1.0 Introduction

The purpose of this document is to detail the recommendation/issue and response of the project team to each of the submissions received relating to the Picton High School redevelopment (SSD 17_8640). The project was on public exhibition between 10 May 2018 and 8 June 2018. Three public submissions were received in addition to formal submissions from the following agencies:

Government Architect of NSW

DRAWING NUMBER
AA21-0001
SCALE
1:50 @ A3

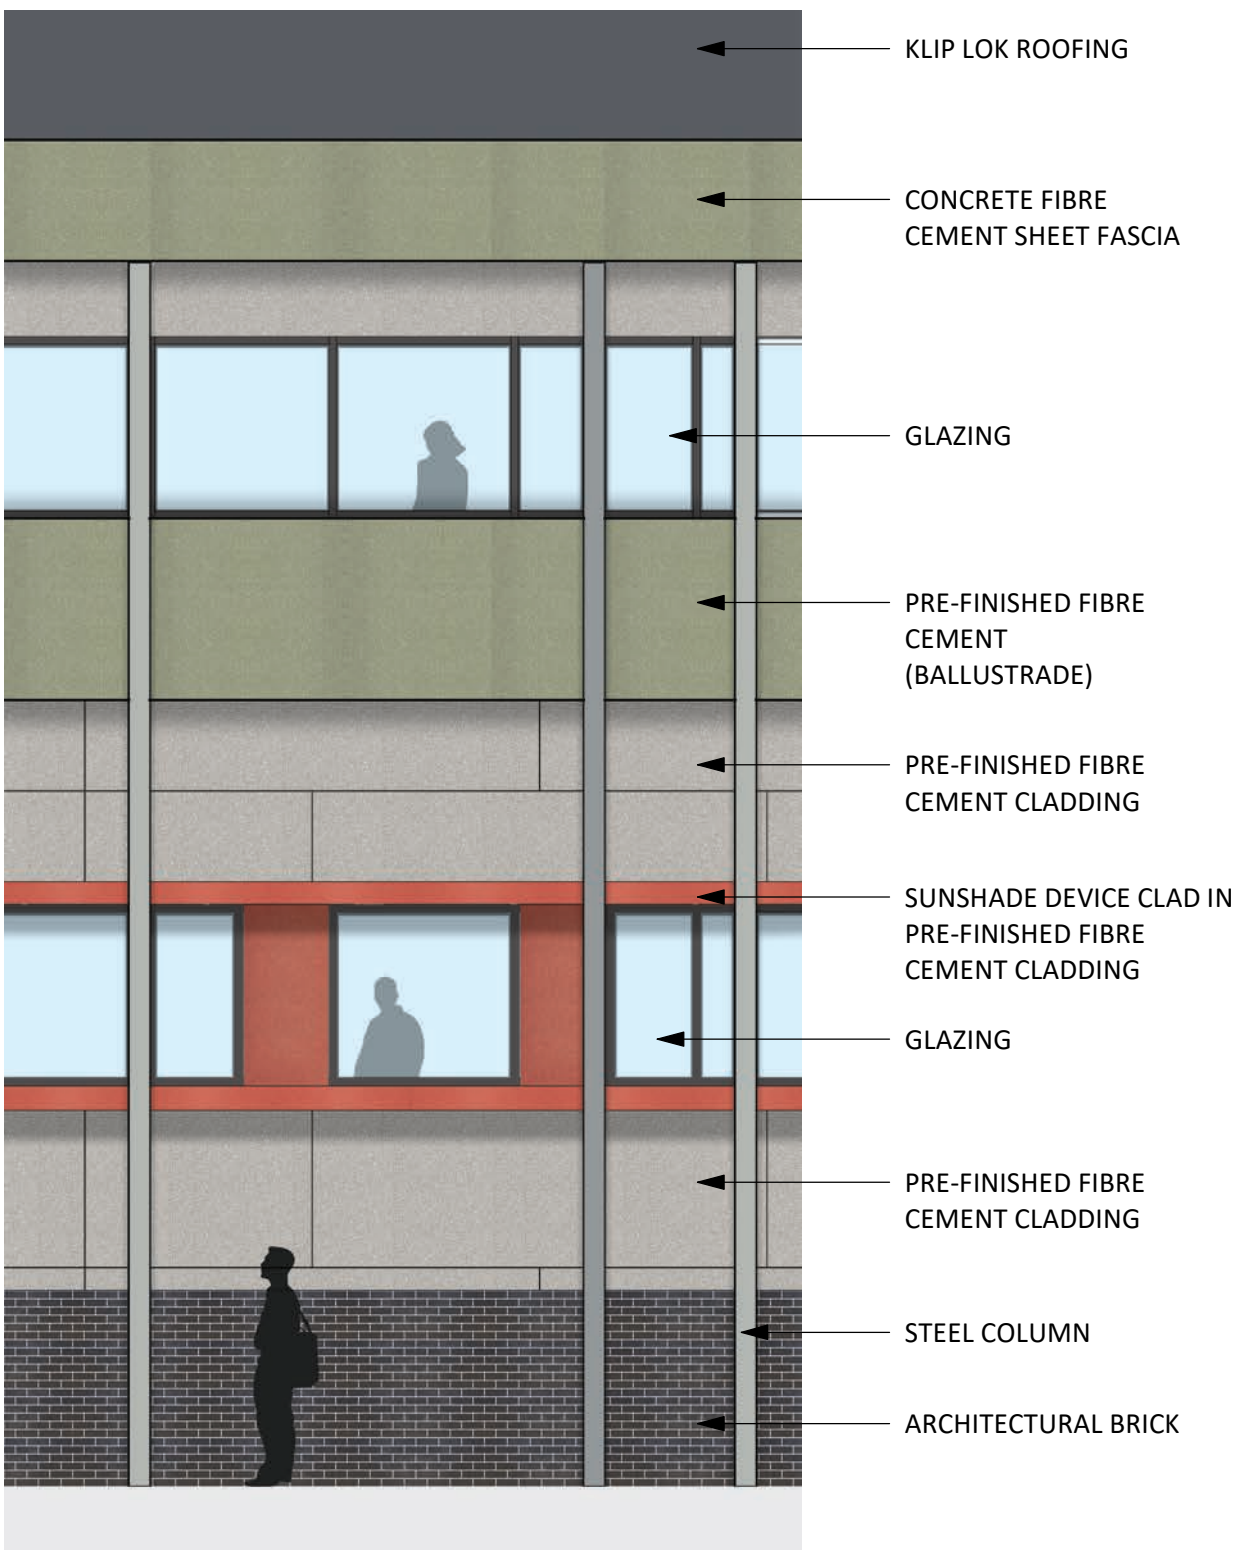
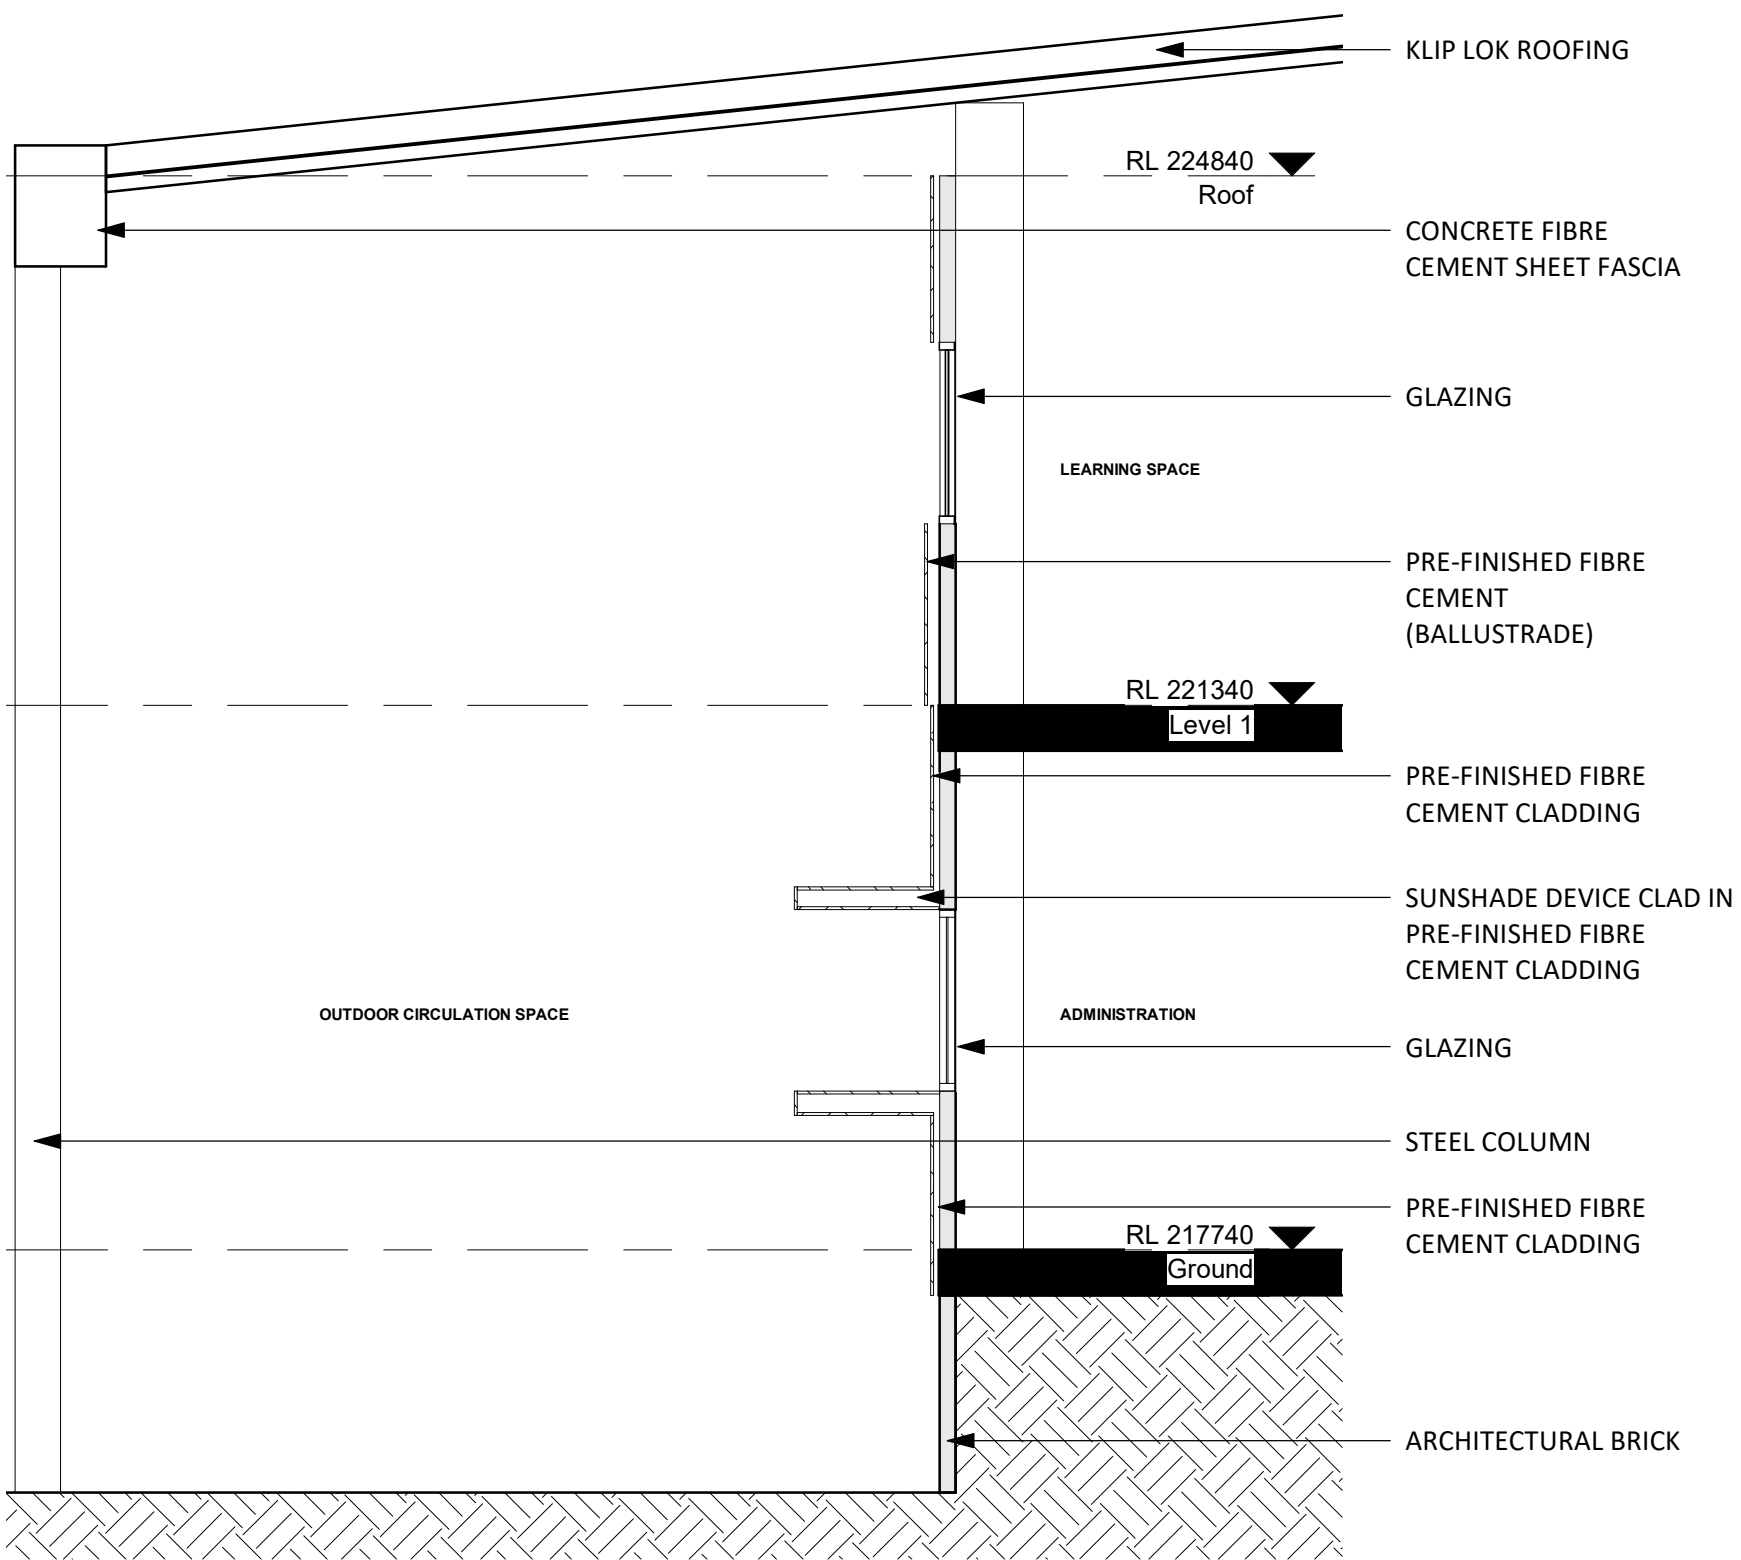
Recommendation/Issue	Comment
1:50 section / elevation details of other key façade types	These drawings have been provided at Attachment B to the Response to Submissions letter. Specifically, key façade types are shown in Drawing AA21-001.
